From: Andrew
Sent: 09 August 2022 09:12
To: Watkinson, Gregory
Cc: Polly Harris-Gorf; _planningadvice; Whelan, Marc; Fisher, Andy (BBC); Carl
Subject: AMENDMENT 1 - H16-0704-22 & H16-0705-22 - Mary Ann Johnson Drinking Fountain (A1572F)
Attachments: A1572-02 Rev P6.pdf; A1572F Fountain HIA Rev P6 FINAL railings.pdf; A1572F - Planning amendment form 09.08.22.pdf

Drawing Number:	Rev:
A1572-02	P6

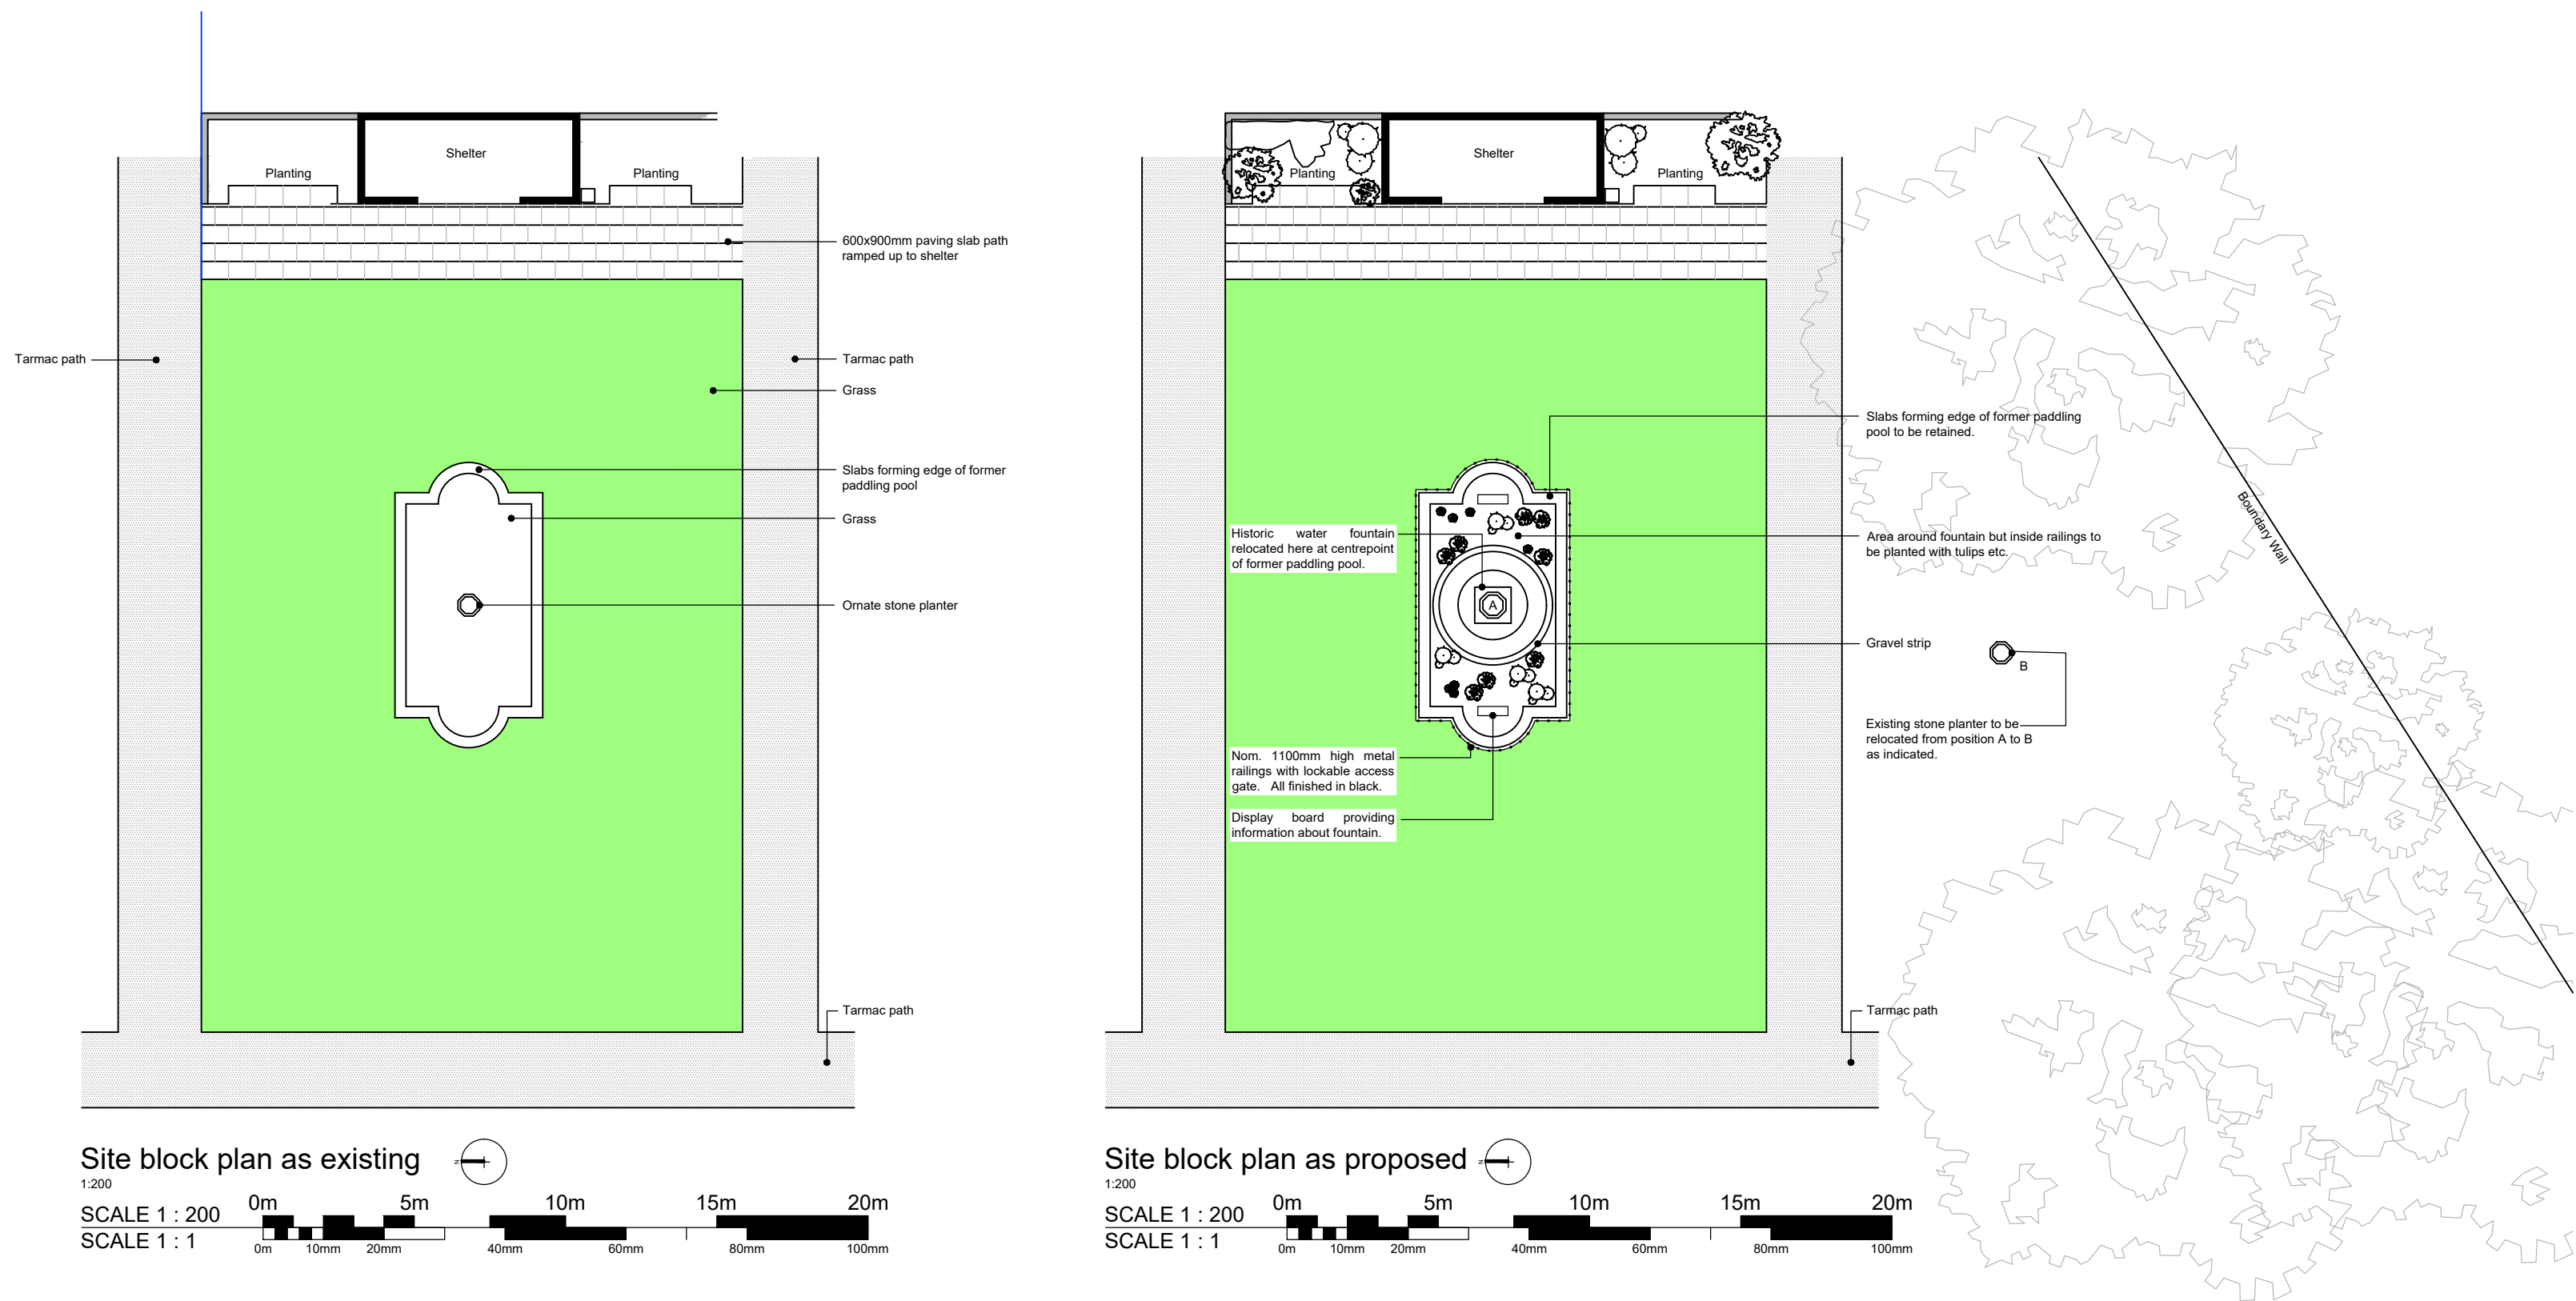
The drawing now shows the line of the railings immediately outside of the outer edge of the slabs surrounding the former paddling pool. This appears to accord with both your comments and those returned by David Walsh at HE.
